CITY OF ALBUQUERQUE

**RE: Lot 16-A(1)
Interstate Industrial Tract, Unit 5
Grading and Drainage Plan (Stamp Date 11/6/2015)
Hydrology File: D17D104**

Based upon the information provided in your submittal received 11-06-2015, the above-referenced plan cannot be approved for Building Permit until the following items are addressed:

GRADING & DRAINAGE PLAN

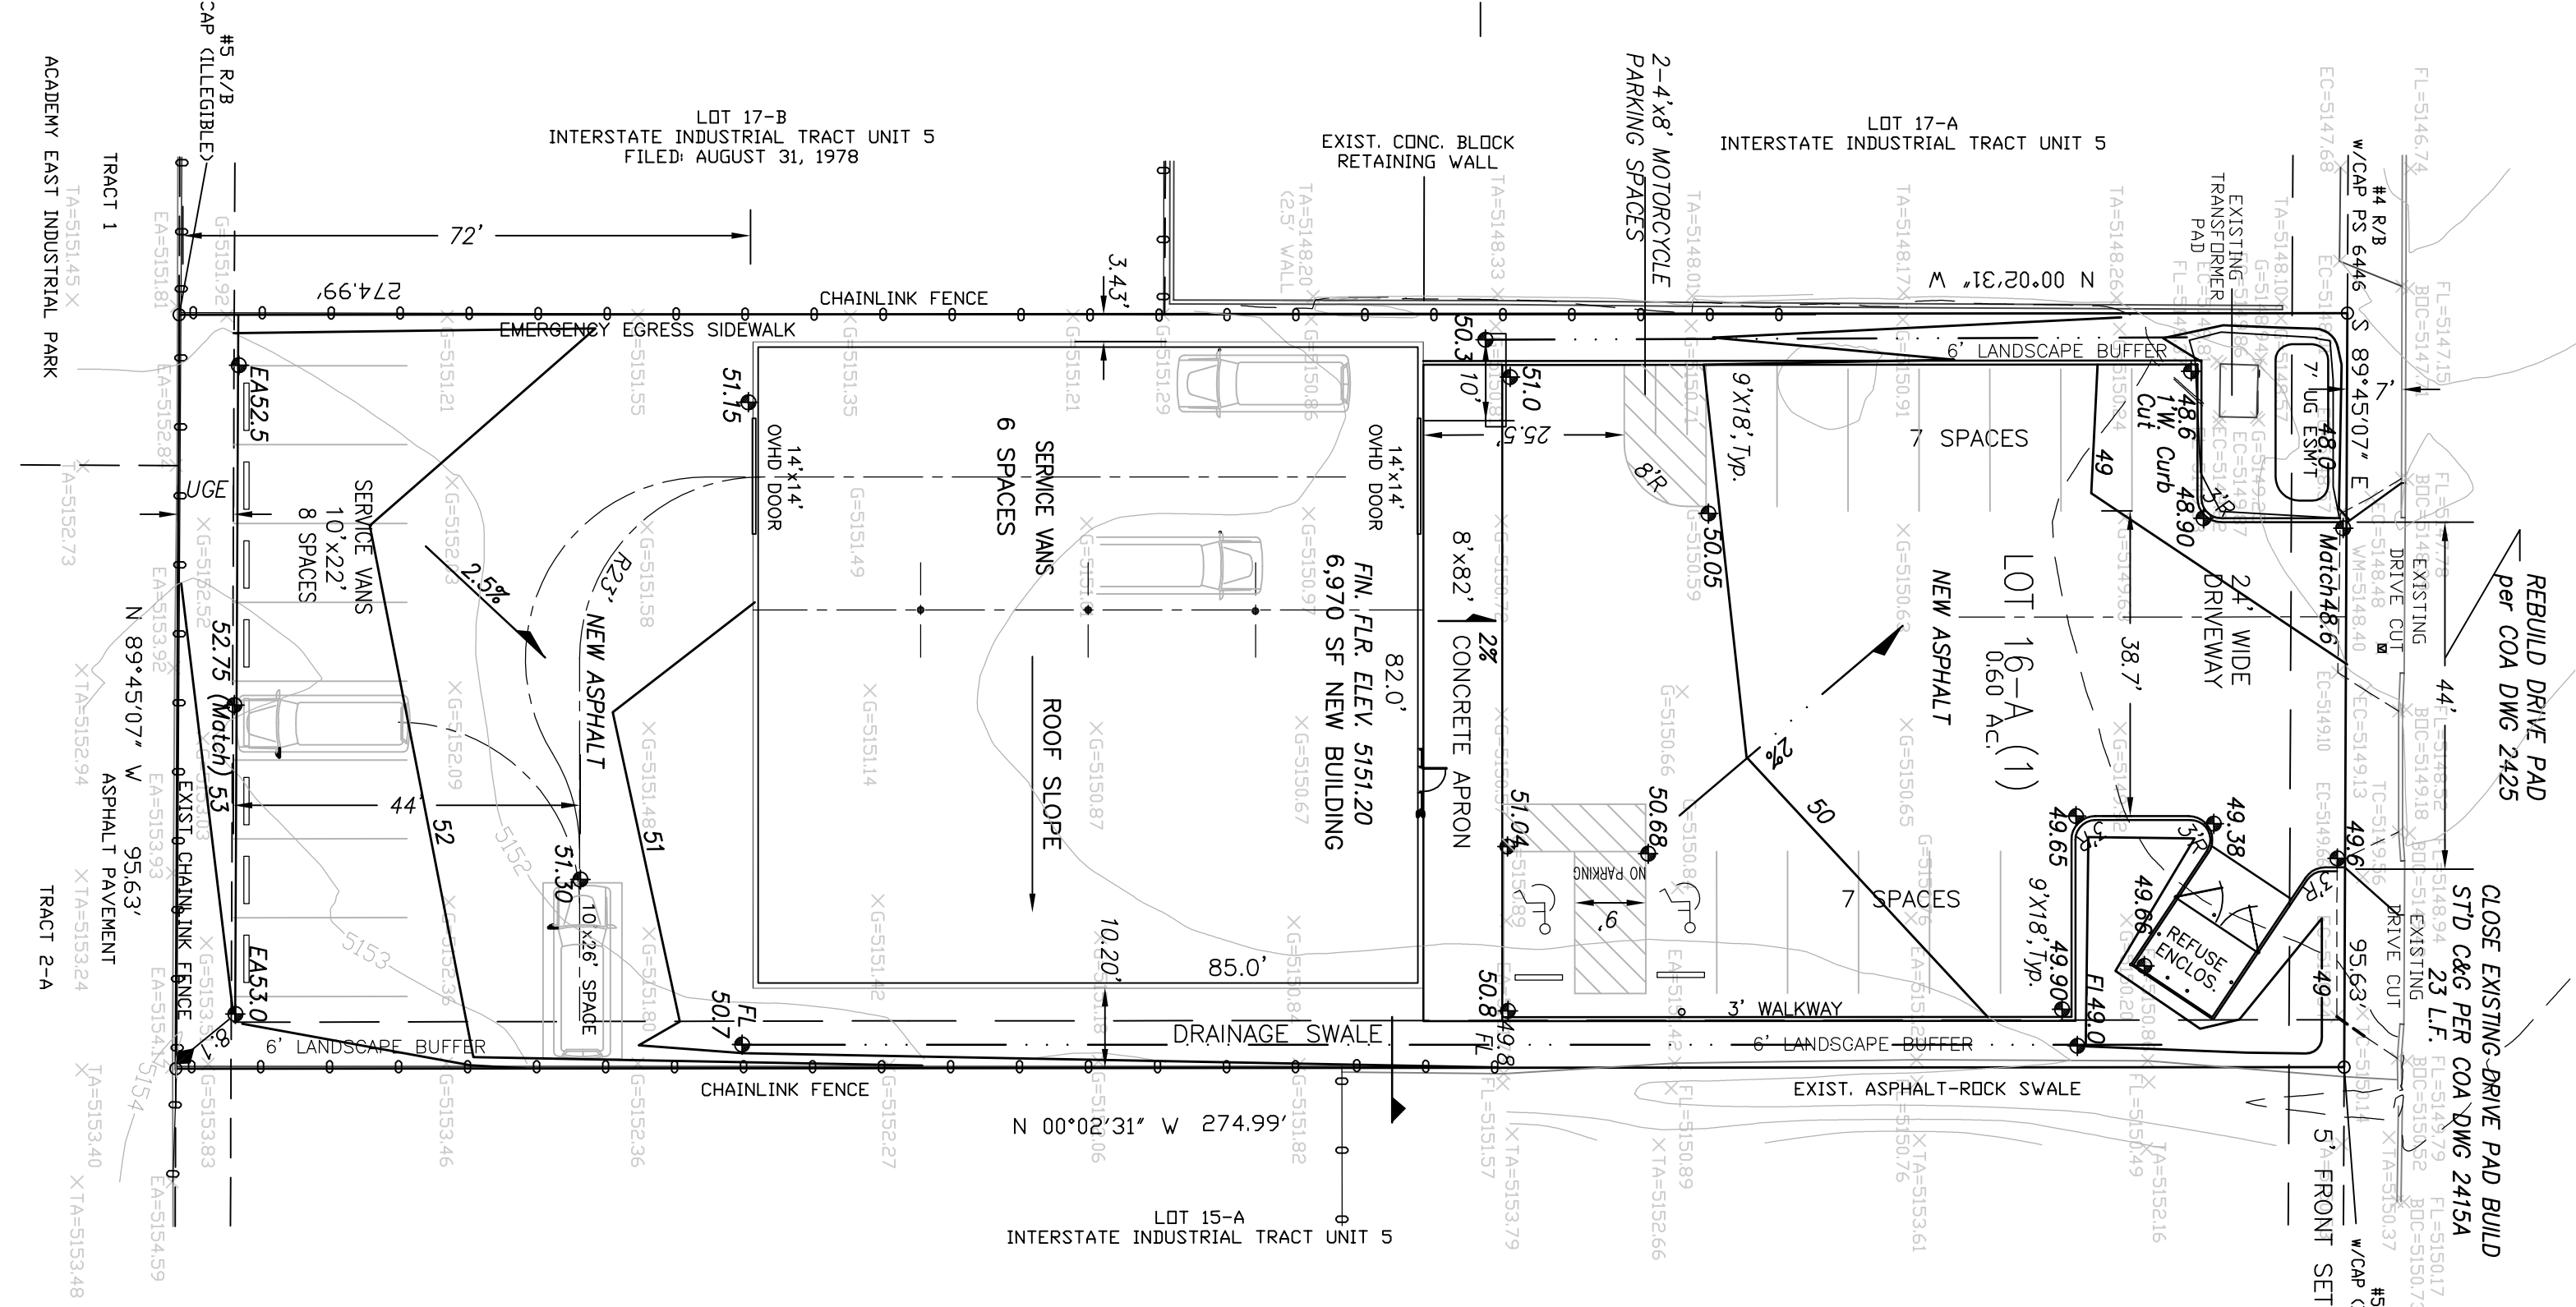
1. The first flush volume must be managed on site, per the City's Drainage Ordinance: <https://www.cabq.gov/planning/documents/SignificantDrainageOrdinanceChanges0414.pdf>, effective May 2014. The first flush volume is equal to the impervious surface area times 0.44 inches (minus 0.1 inches for initial abstraction). Landscaped areas may be depressed and used for first flush volume routing.
2. Roof flows (to the most practicable extent) must be routed through a first flush pond
